PORTLAND MAINE

September 27, 2007

RE: 349 Park Avenue – H.P. Hood – 066 D001 – IM – concrete pad/pile cap & 5,000 gallon sugar tank – permit # 07-1149

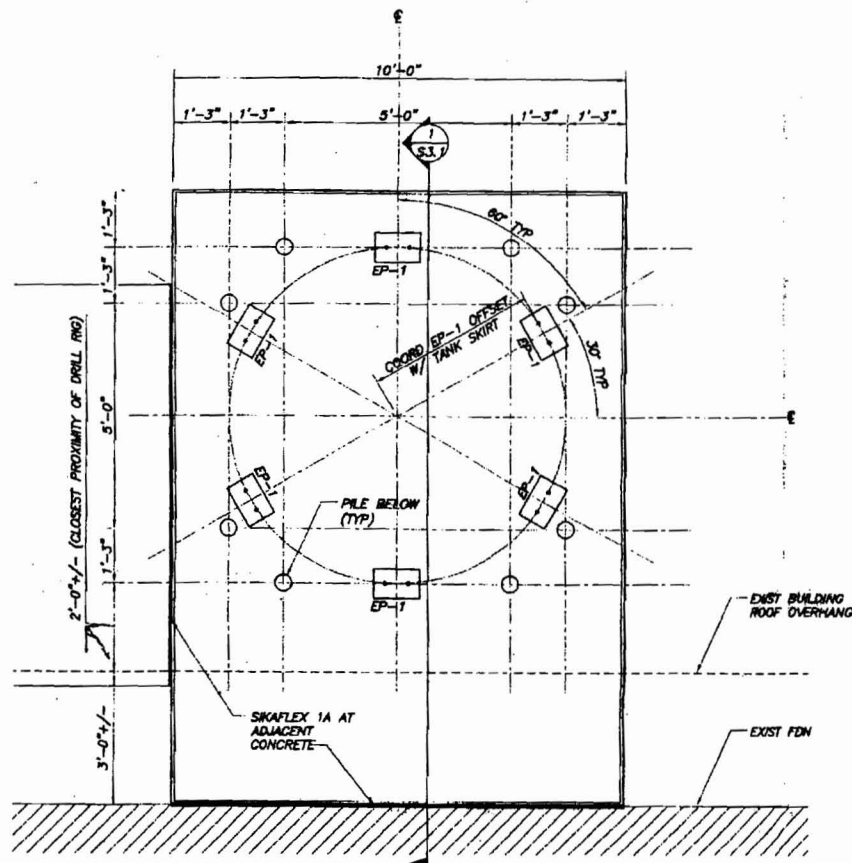
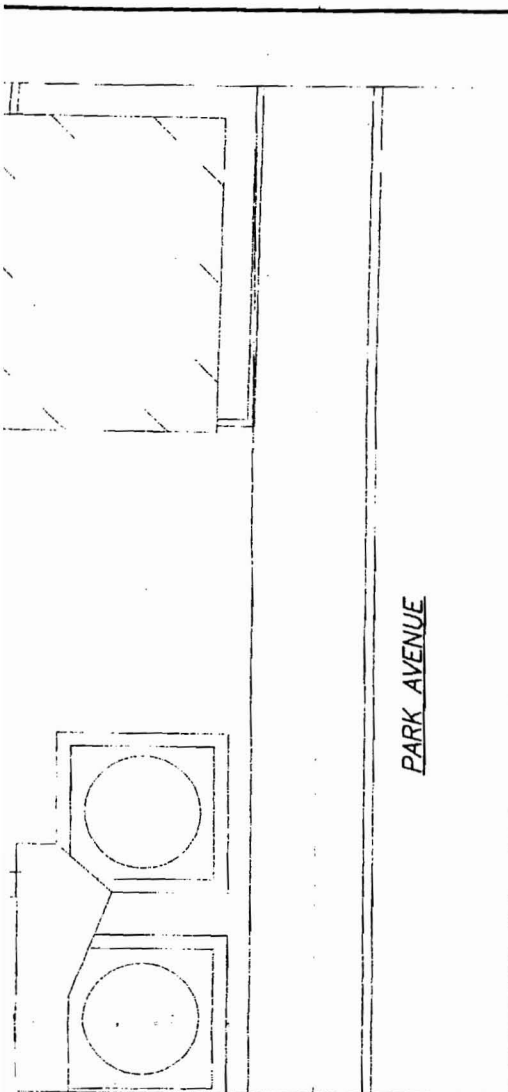
I am in receipt of the application to pour a concrete pad for a 5,000-gallon sugar tank at the H.P. Hood building at 349 Park Avenue. In reviewing the application, it has come to my attention that the proposed pad and tank does not meet the required side setback. The property is located in the IM zone. Section 14-250(d) of the ordinance, states that the minimum side yard in the IM zone is one foot for each one foot of building height up to twenty-five feet. Since the proposed sugar tank is twenty-five feet tall, the required minimum side setback is twenty-five feet. The plan that was submitted with the application shows the setback to the side property line as five feet four inches. Since the proposed structure does not meet the minimum required setback, I must deny the permit.
